From: Contact Centre (CRM) <contact@ribblevalley.gov.uk>
Sent: 20 August 2023 16:40
To: Planning
Subject: Planning Application Comments - 3/2023/0488 FS-Case-540660499

Planning Application Reference No.: 3/2023/0488

Address of Development: The Old Printworks 4a & 6a Back York Street BB7 1LT
Grid Ref 374496 441958

Proposed Elevations 1:100 @ A3

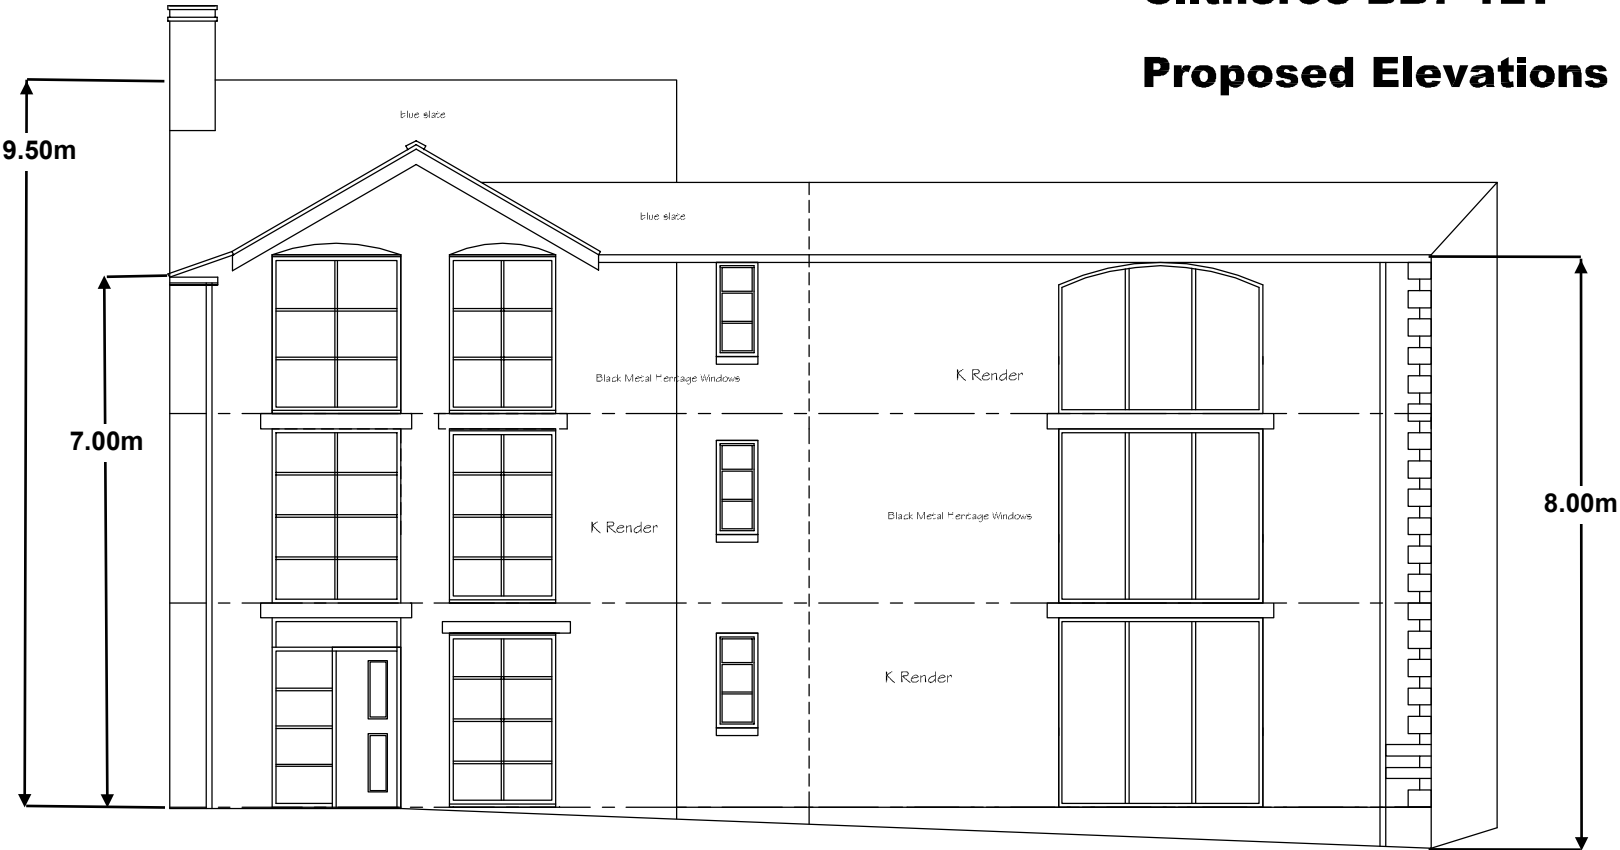
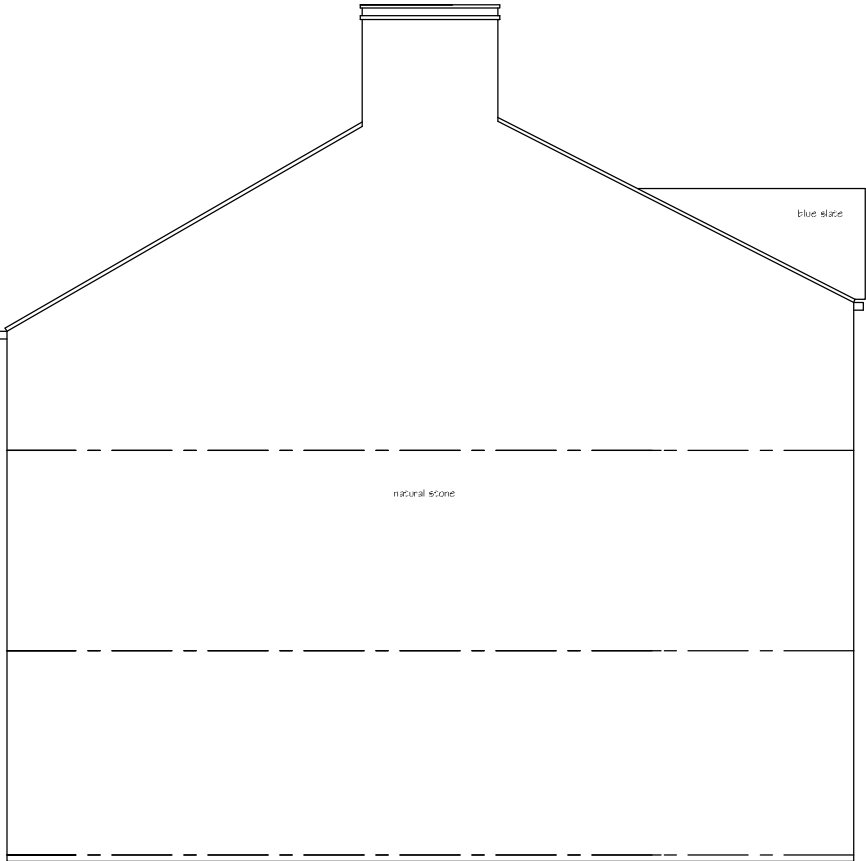
Secondly, the rear stone gable elevation abuts the rear yard of no8 York Street. There is currently a window opening at first floor level with a fixed casement featuring obscured glazing, without an opener. It was likely built like this [REDACTED] no issue with this. However, we feel it inappropriate to create two more window openings; one above and one below the existing window. [REDACTED] have particular issue with the proposed opening on the ground floor [REDACTED] [REDACTED], which [REDACTED] creating [REDACTED] Were these windows not to be fixed casements as the existing one is, [REDACTED] anticipate a security issue as they are in the vicinity of a darkened yard [REDACTED] metal security railings [REDACTED] to discourage any criminal activity in what is a dark secluded place at night. [REDACTED] consider it foolish to offer unnecessary invitations. No 8 York Street is currently a commercial property, but if it were to resume being a residential dwelling in the future, no one would want someone's bedroom window at ground floor level, overlooking their yard .

Proposed Floor Plans 1:100 @ A3

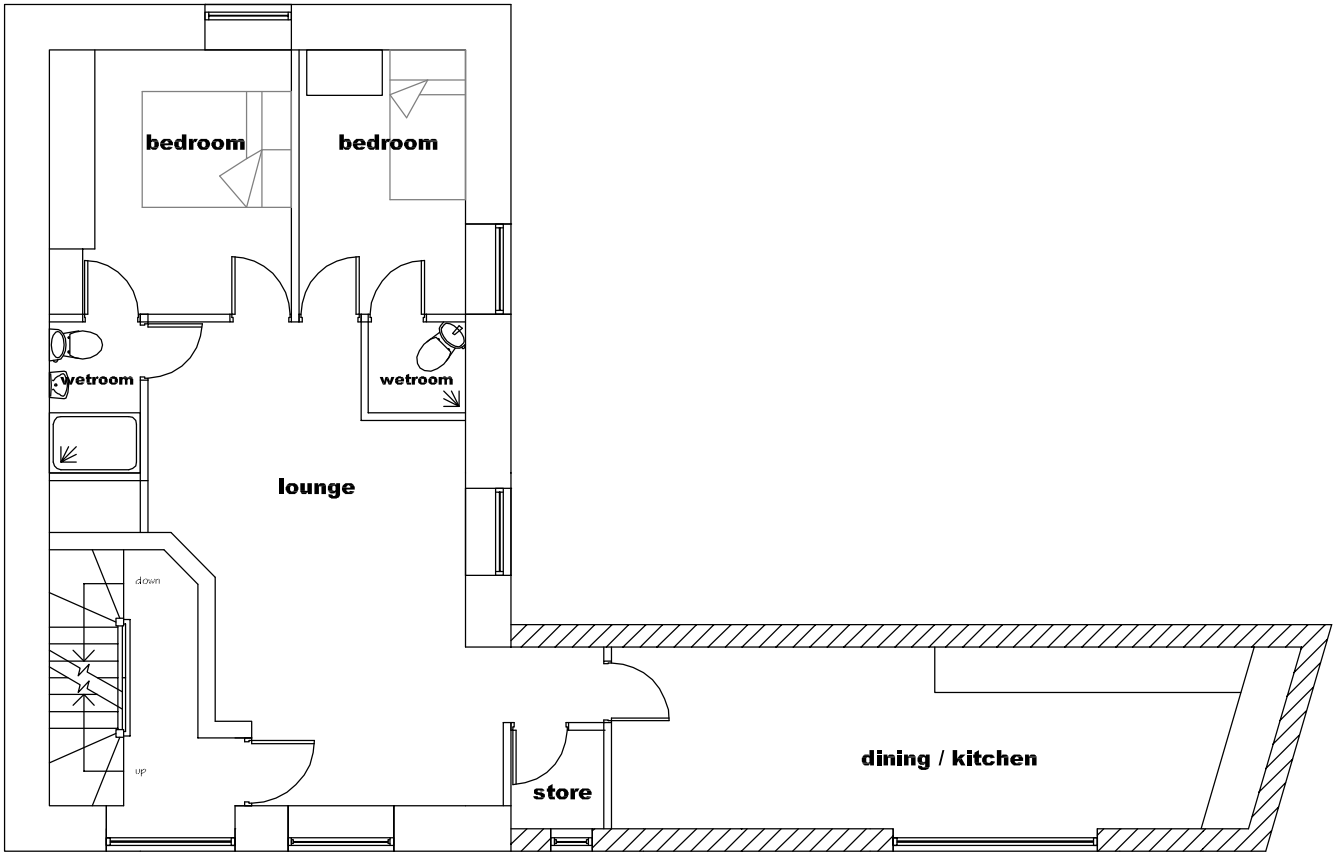
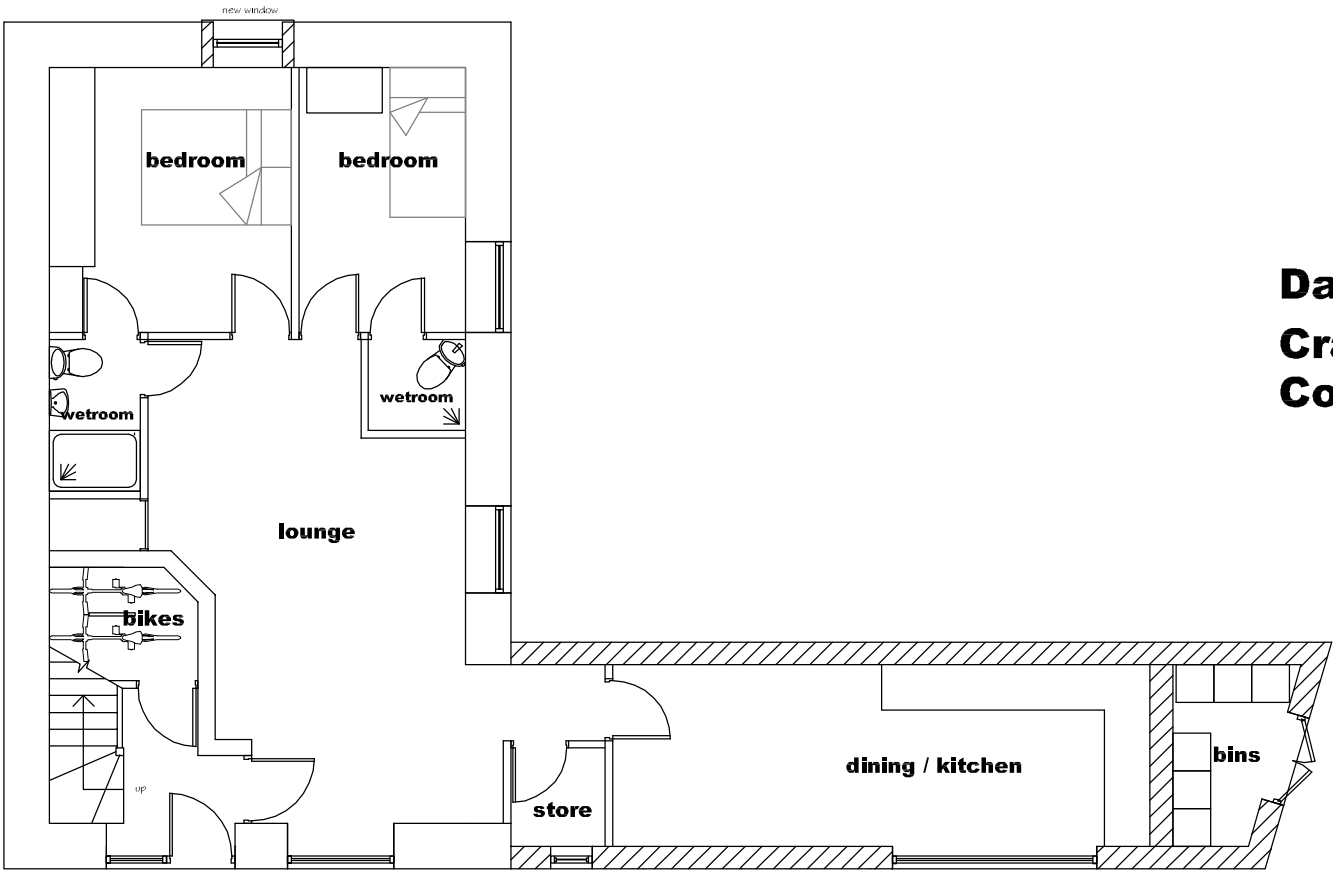
Firstly, the brick building intended for demolition and rebuilding a storey higher, abuts a courtyard in the joint ownership of the proprietors of 8a & 8 York Street. The courtyard is used for vehicular parking and both 8 & 8a require access for parking. Due to the tightness of it's turning point, the original brick wall has a chamfer, though significantly the plans do not show the new wall built to the same design (without a chamfer). For continued access to [REDACTED] parking spaces, the rebuilt wall needs to be no worse, but ideally an improvement on the existing design.
